# CITY OF ALBUQUERQUE

RE: **Carvana – 3800 Pan American Freeway NE**  
**ESC Plan Engineers Stamp Date: 3/3/2020 – G16E156**

Based upon the information provided in your submittal received 3/3/2020, the above referenced plan can't be approved to be included in the SWPPP and for NOI Documentation review for Grading and Building Permit.

<b>CARVANA</b> <b>3800 PAN AMERICAN FWY N.E.</b> <b>SWPPP</b>	DRAWN BY RMG DATE 03/11/2020 2020008-SWPPP	
	 <b>TIERRA WEST, LLC</b> 5571 MIDWAY PARK PLACE NE ALBUQUERQUE, NM 87109 (505) 858-3100 www.tierrawestllc.com	SHEET # <b>10</b> JOB # 2020008

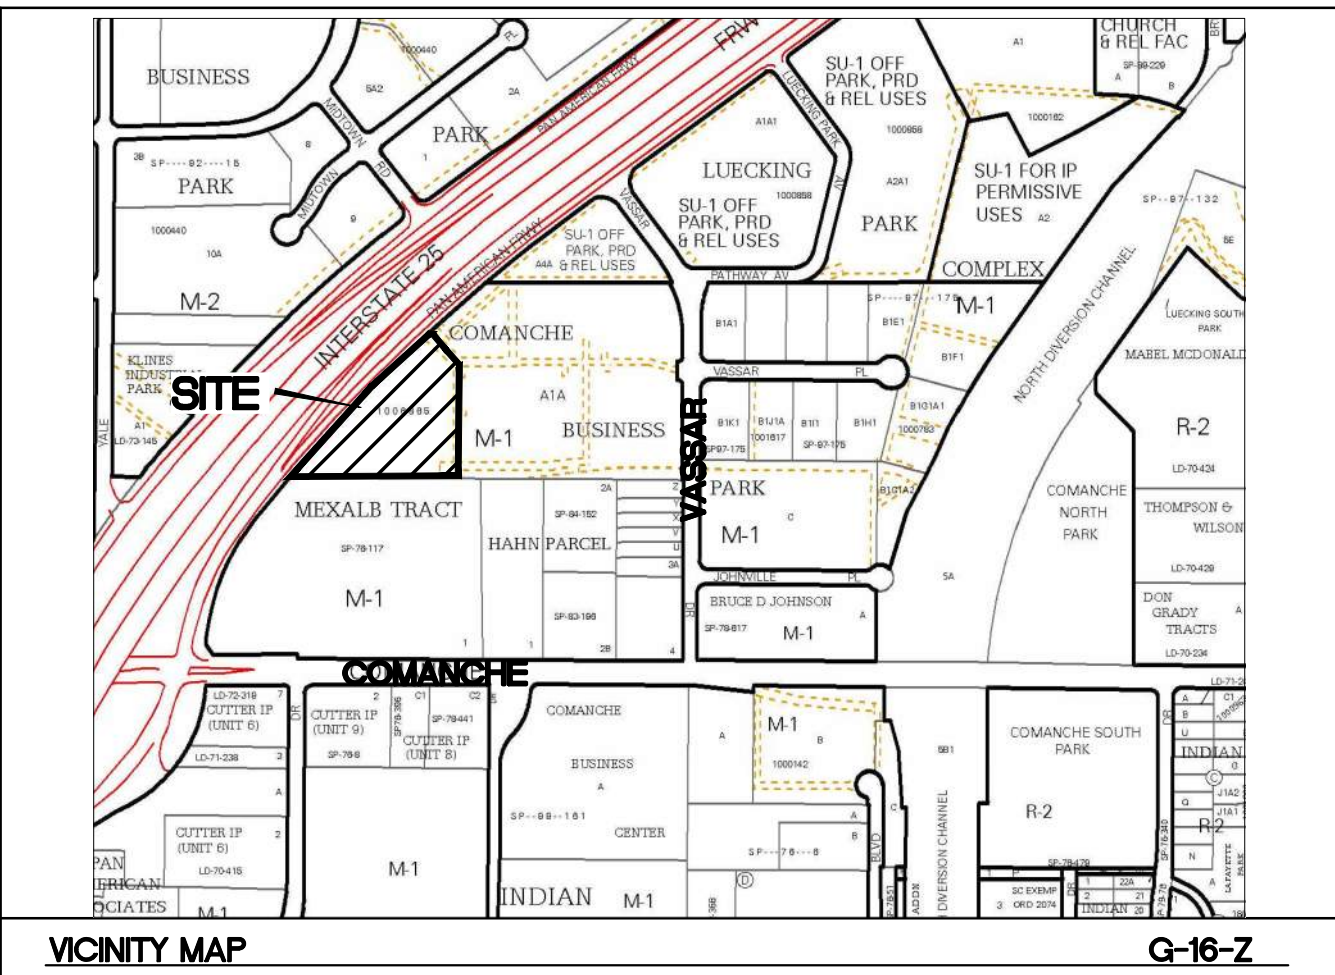
1. Existing Contours are missing. Both existing and proposed contours must be shown on the plan and identified in the legend.
2. The proposed contours must match the approved G&D plan. The plan currently under review in Hydrology shows two or three ponds that also need to show up on the ESC Plan.

3. Please add a note on the plan that "the ponds are to be graded as the first item of the earthwork construction and are to be maintained as temporary sediment traps during construction".

4. The location of the limits of disturbance and silt fence should be adjusted to the back of sidewalk along the I-25 frontage Rd.
5. The property owner must be correctly identified on the Information Sheet and the contact must be a duly authorized representative of the corporation. ABQ Comanche Retail LLC appears to be the current owner. Revise the Information sheet and resubmit both paper and digital copies or the revised plan along with review fees.
